Portishead Branch Line (MetroWest Phase 1)

9.31 ExA.FI.D4.V1 – List of consequential amendments arising from removal of Work 16D

**Works 16D – consequential amendments arising from removal
of Work from Schedule of Authorised Works**

This document lists the changes required to Order documentation as a result of the Examining Authority's (ExA) decision of 22 December 2020 (PD-012) to permit the removal of Work 16D from the proposed DCO Scheme.

Drawing
RAILWAY LANDSCAPE PLANS
(DISUSED LINE)
SHEET 6 OF 8

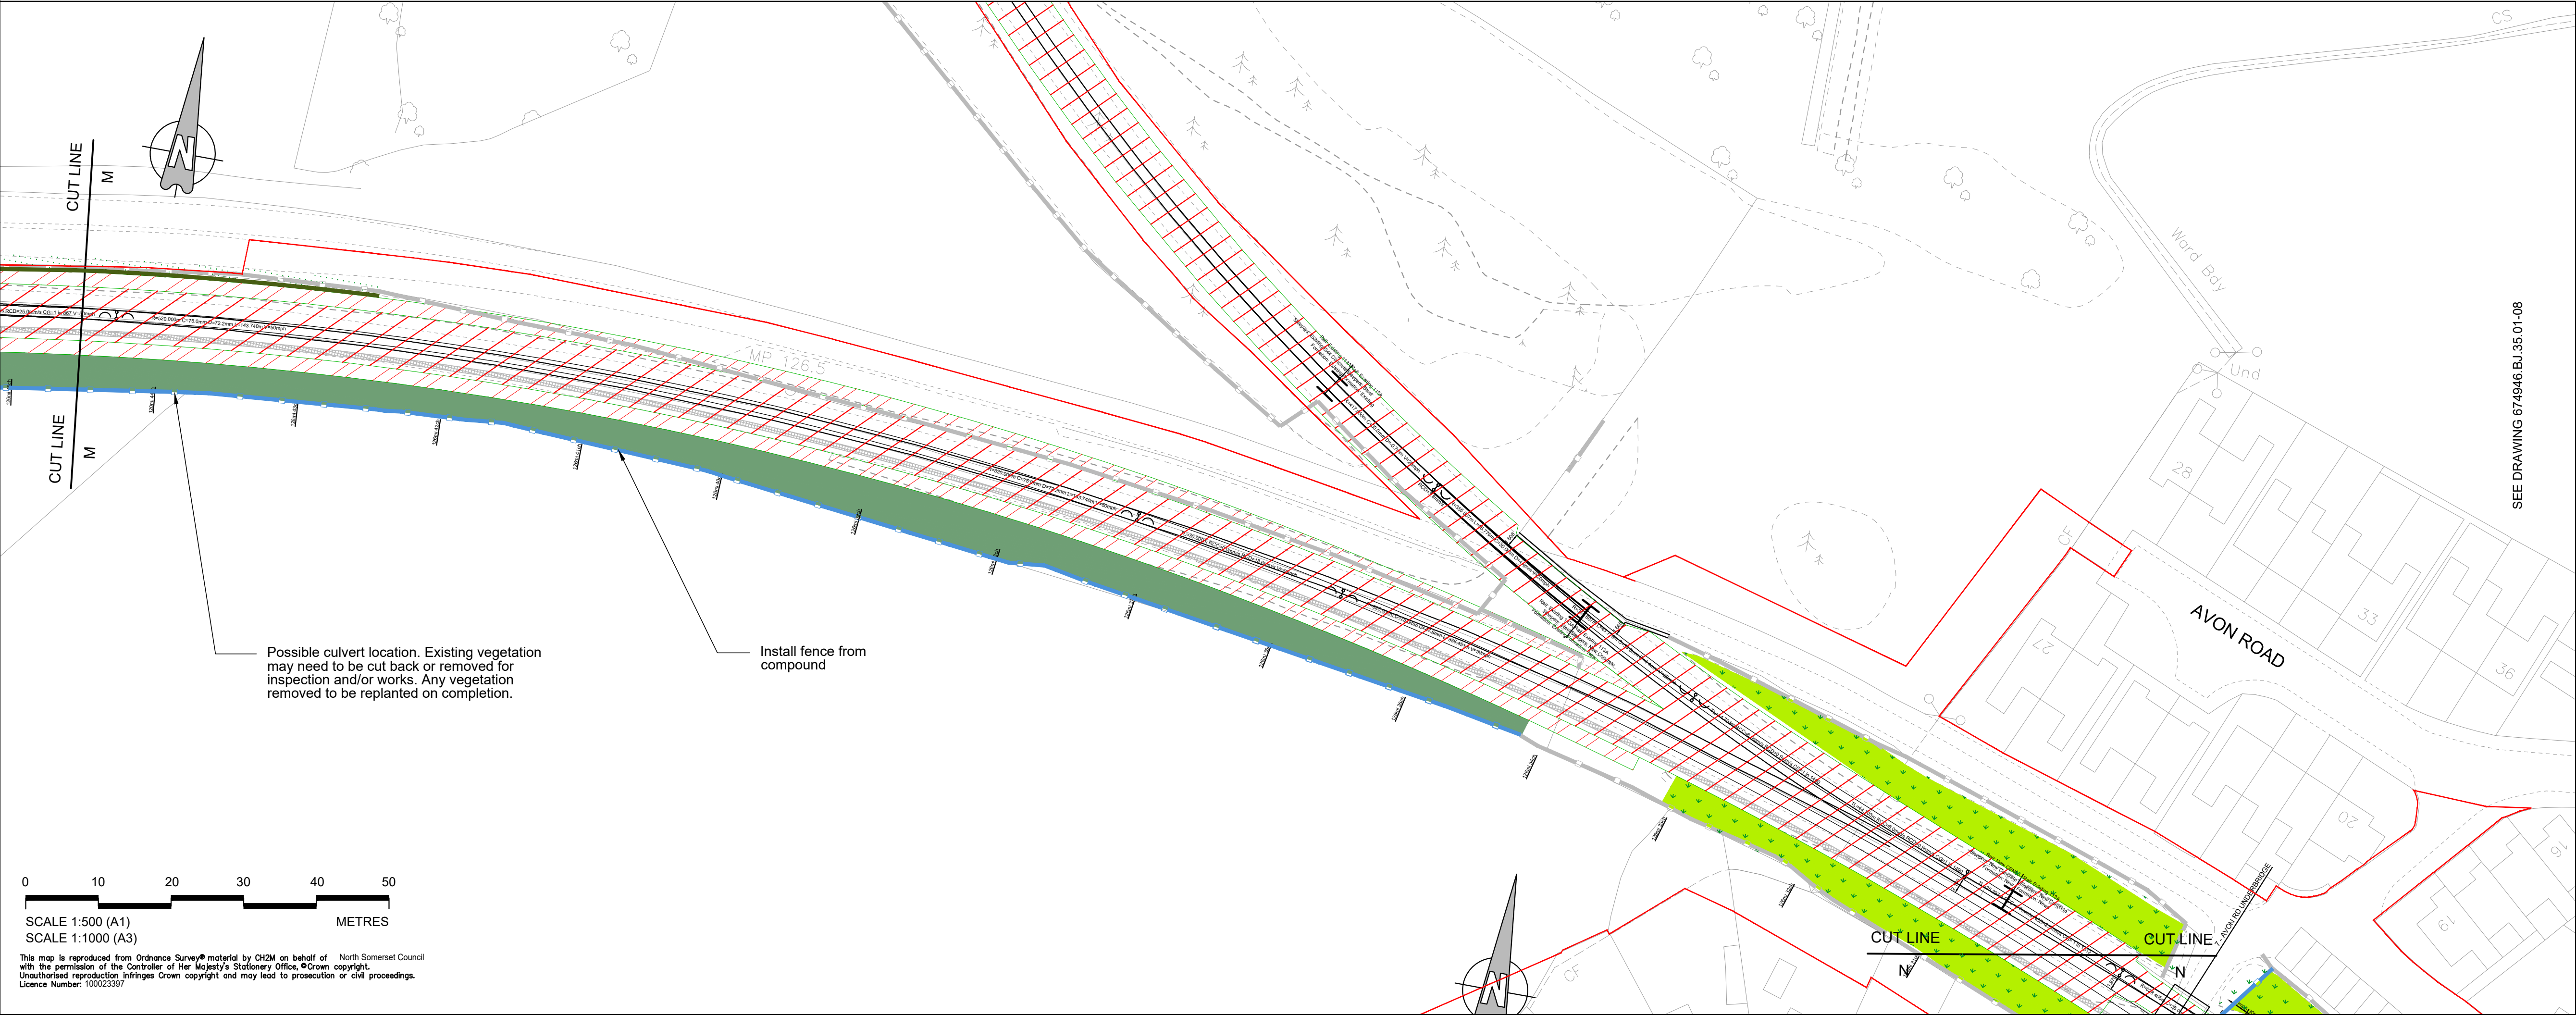
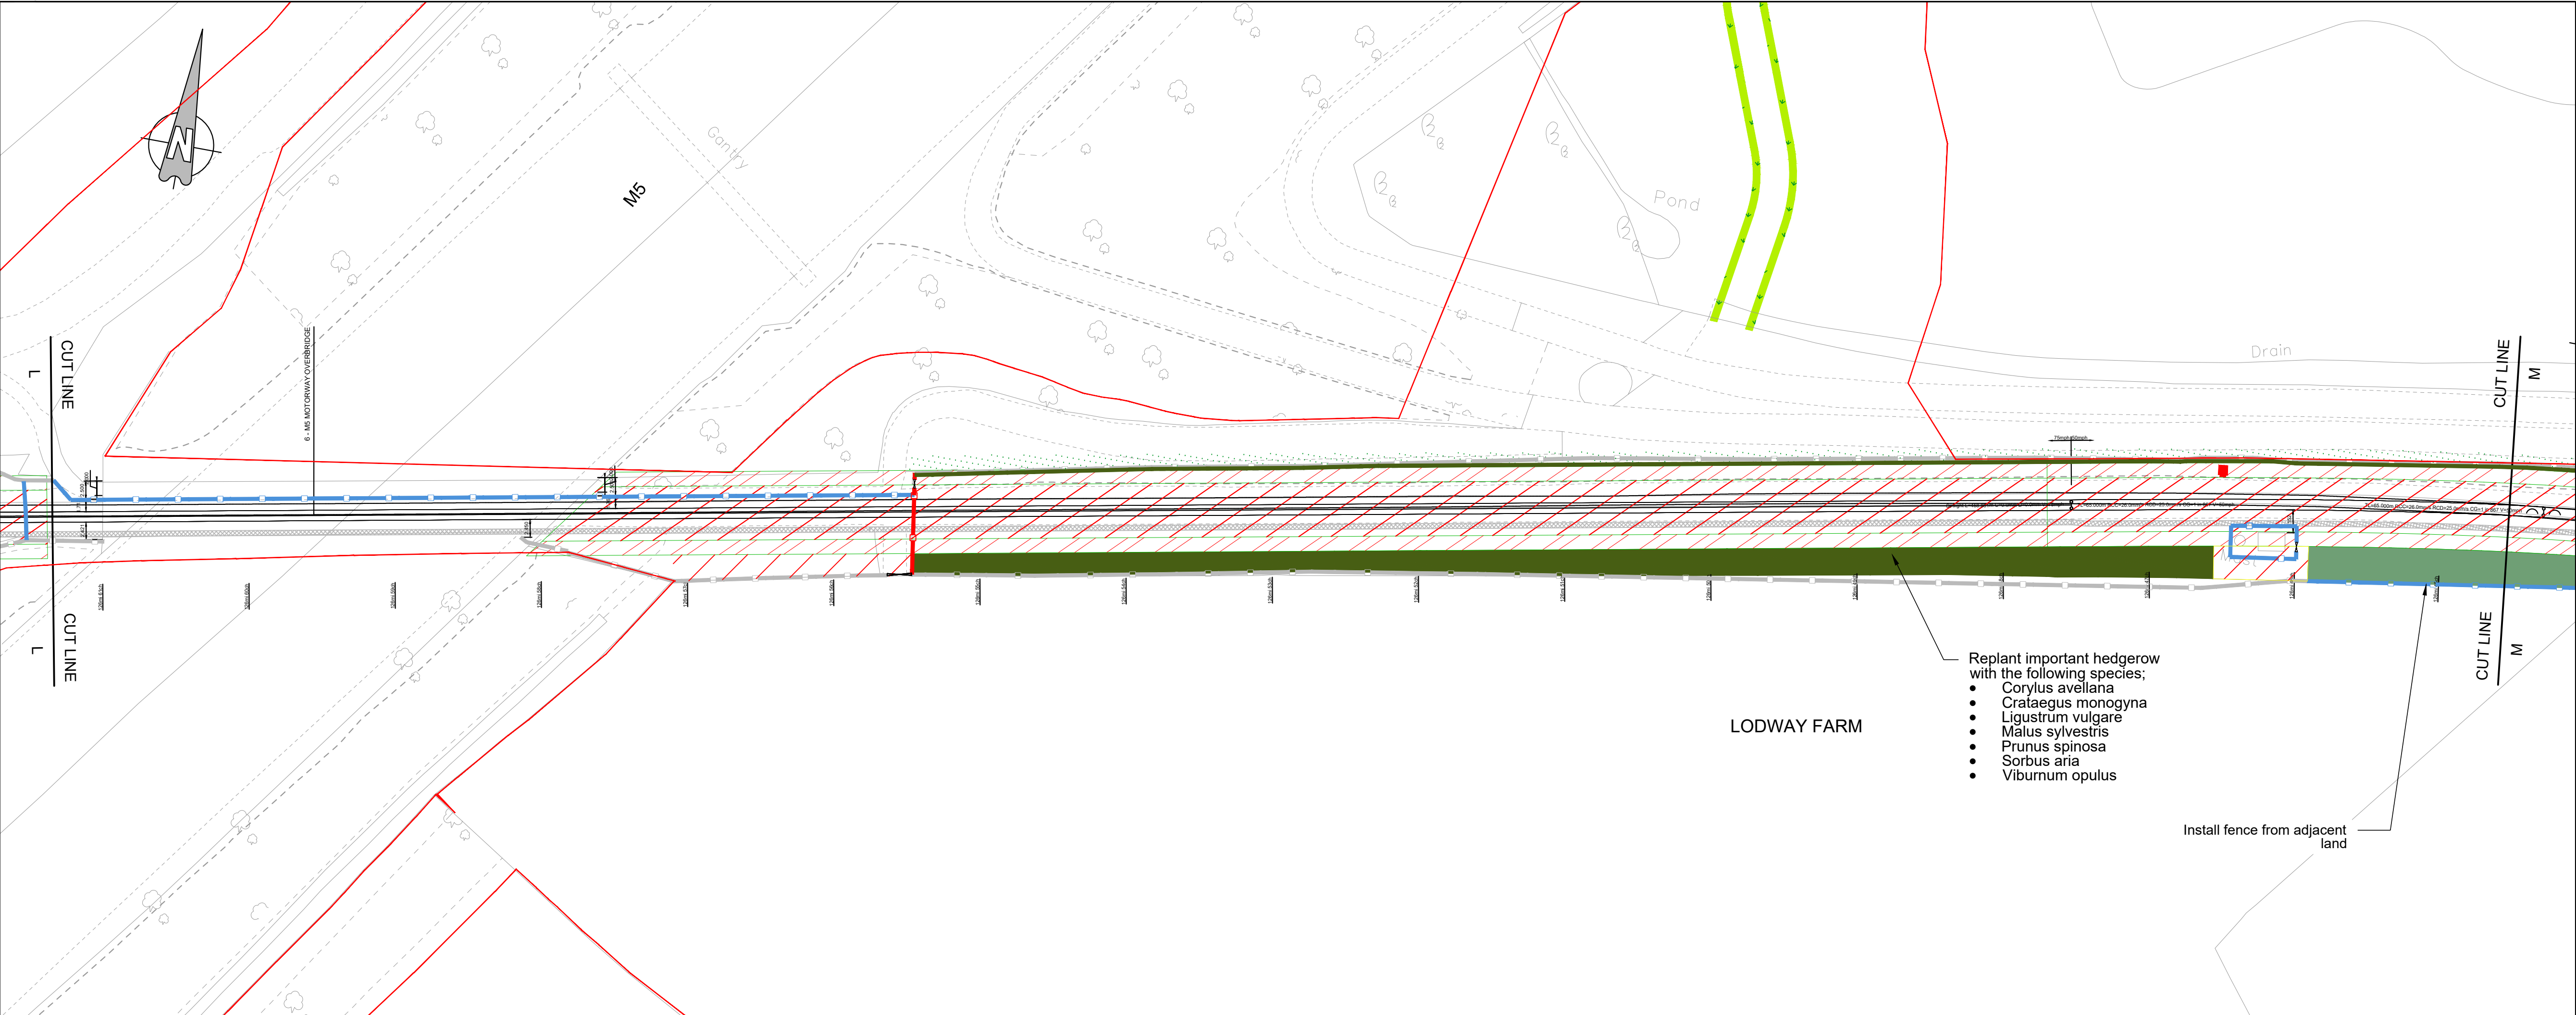
Sheet 6	Landscaping works shown between cut lines K – L	May need to be updated if further landscaping works are required as a result of the changes
<i>Environmental Masterplan (Application Document 2.53: App-045)</i>
